ENG-MS20001-R2-CD-redlines Summary

HORIZ. SCALE: 1"=40'
 VERT. SCALE: N/A
 SURVEYED: RIDGELINE
 CREATED: 10/11/19
 PROJECT NO: 031901
 SHEET: C1.1

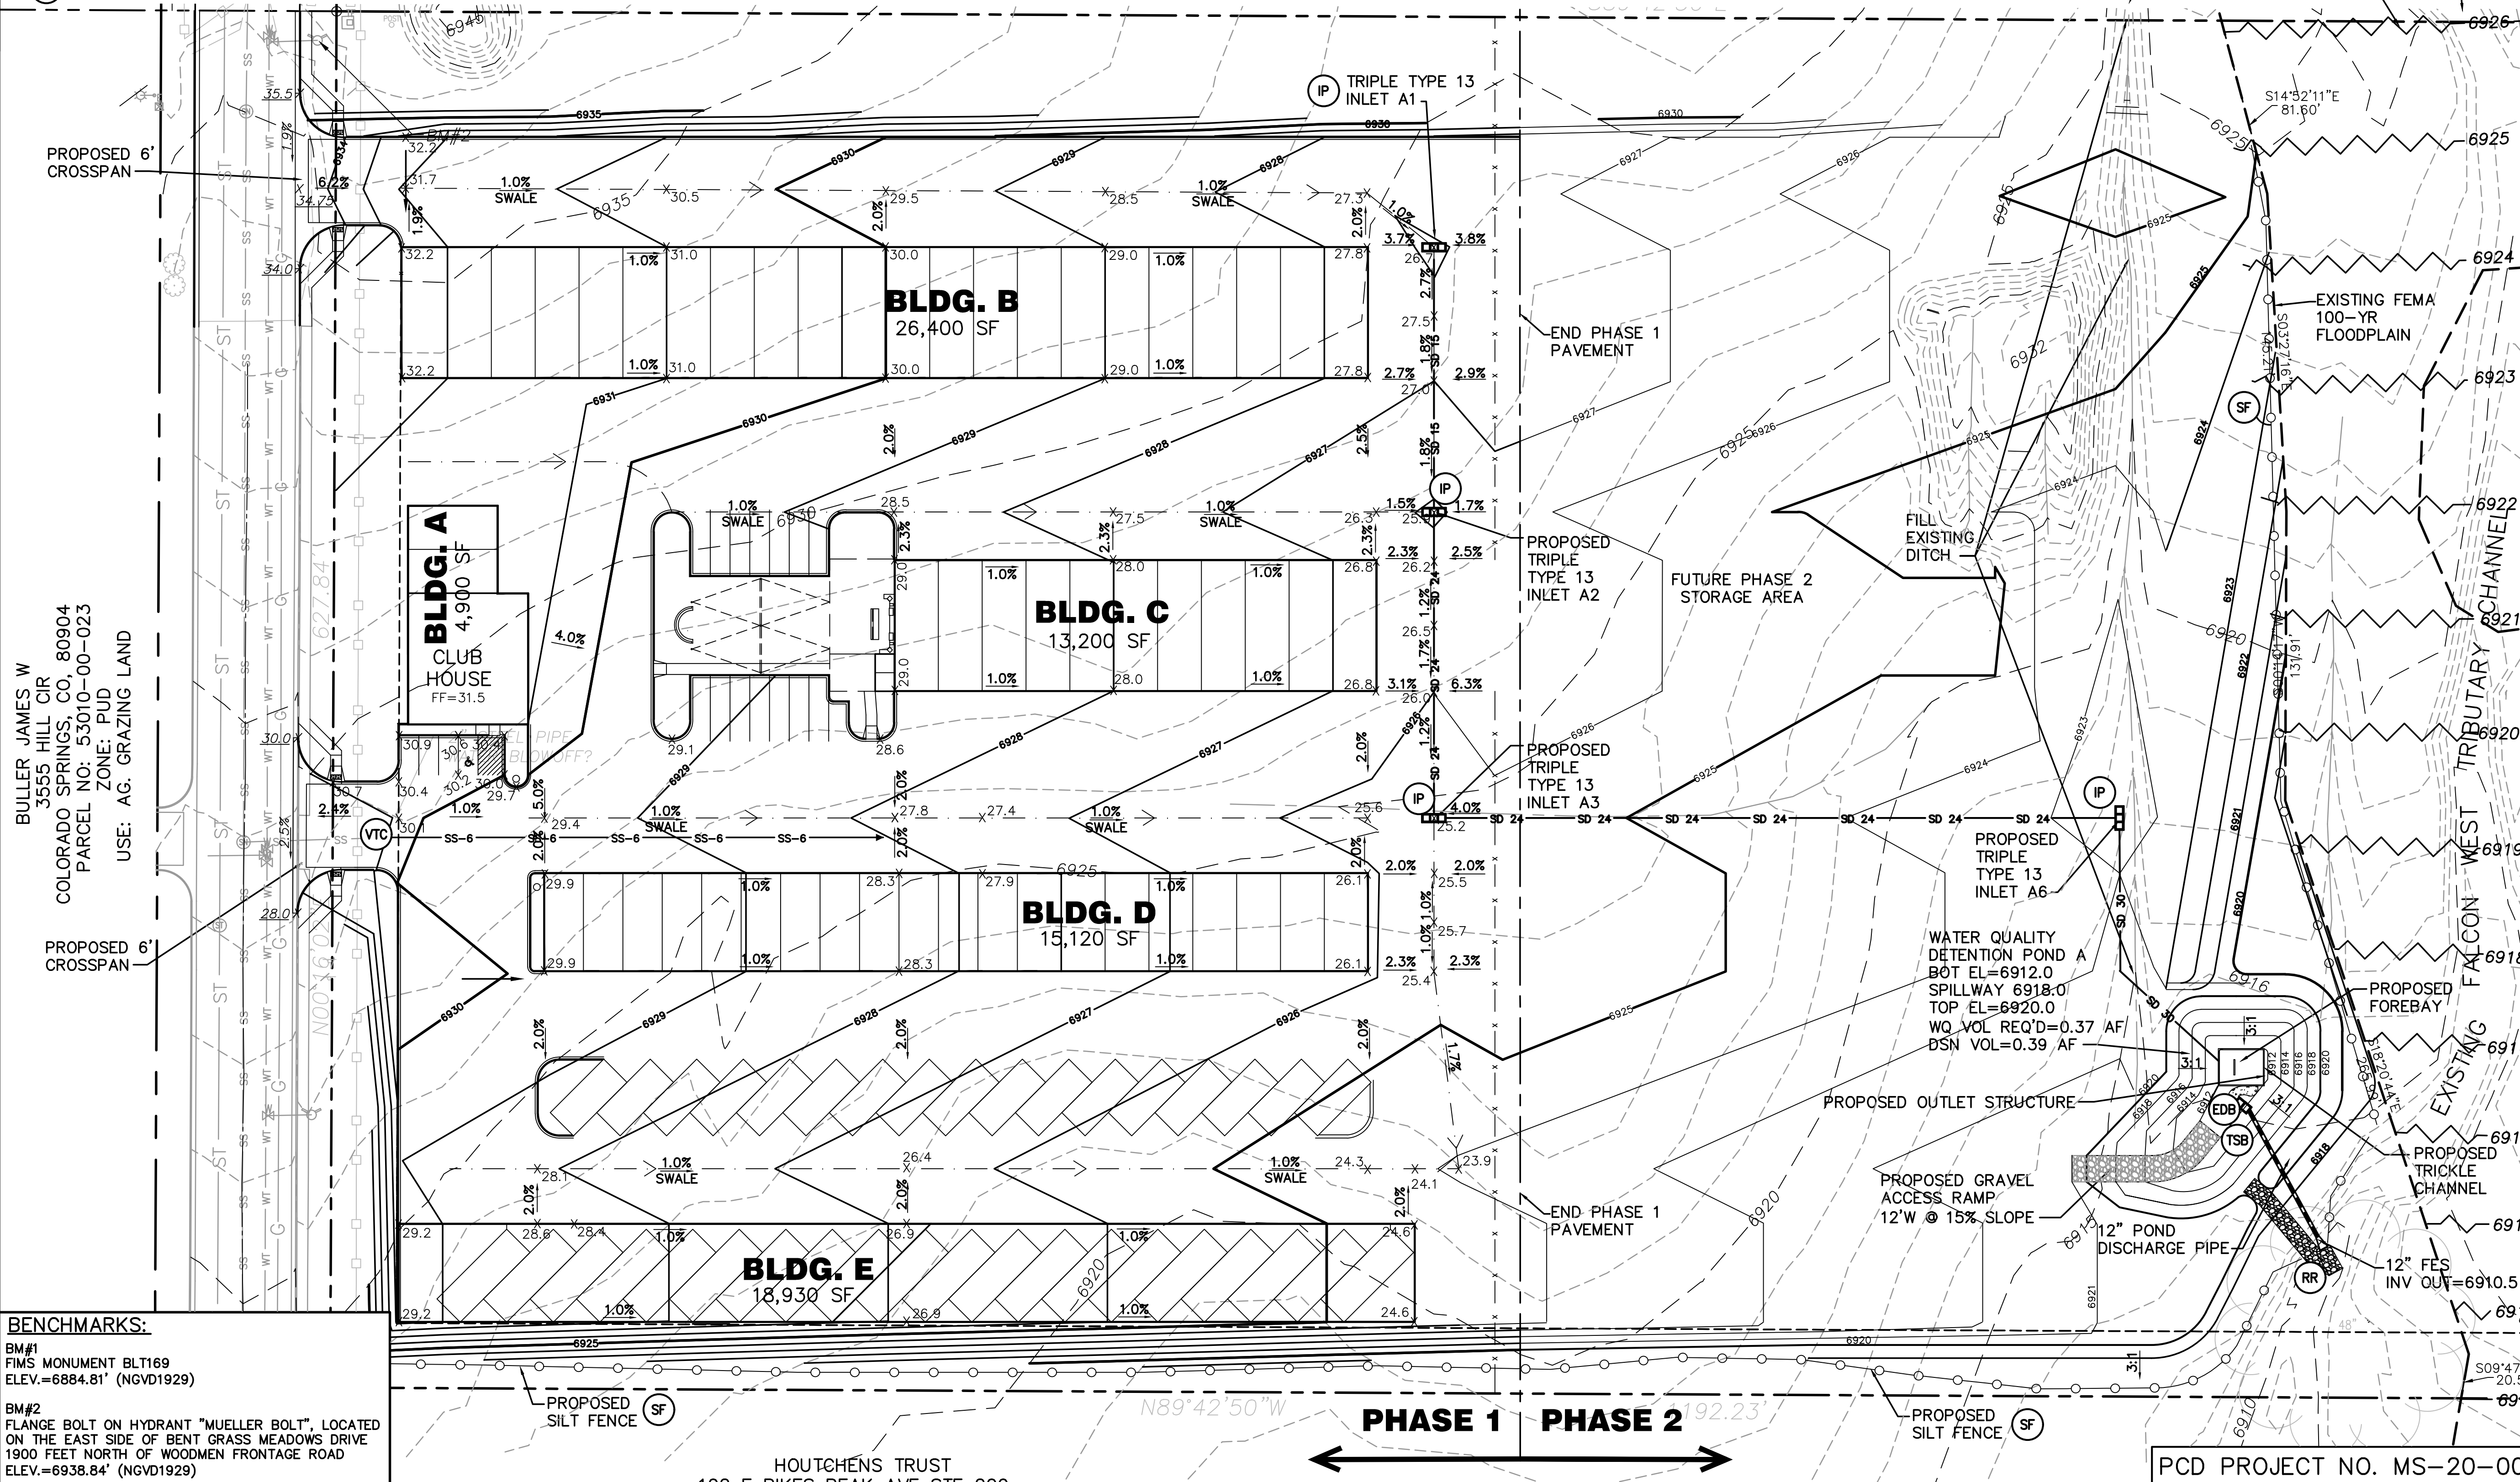
The drainage report indicates 2.83 square inches for the outlet orifices, these slots appear to be too large.

Provide cross-sections across the spillway at the top and midpoint showing dimensions and 100-year depth. This will be regularly overtopping for storms releasing over ~6 cfs based on the outlet pipe and restrictor size; additional detailing of the spillway and channel protection is required. A check structure (potential drainage fee offset) may be required in the channel to prevent headcutting upstream from the new point discharge location.
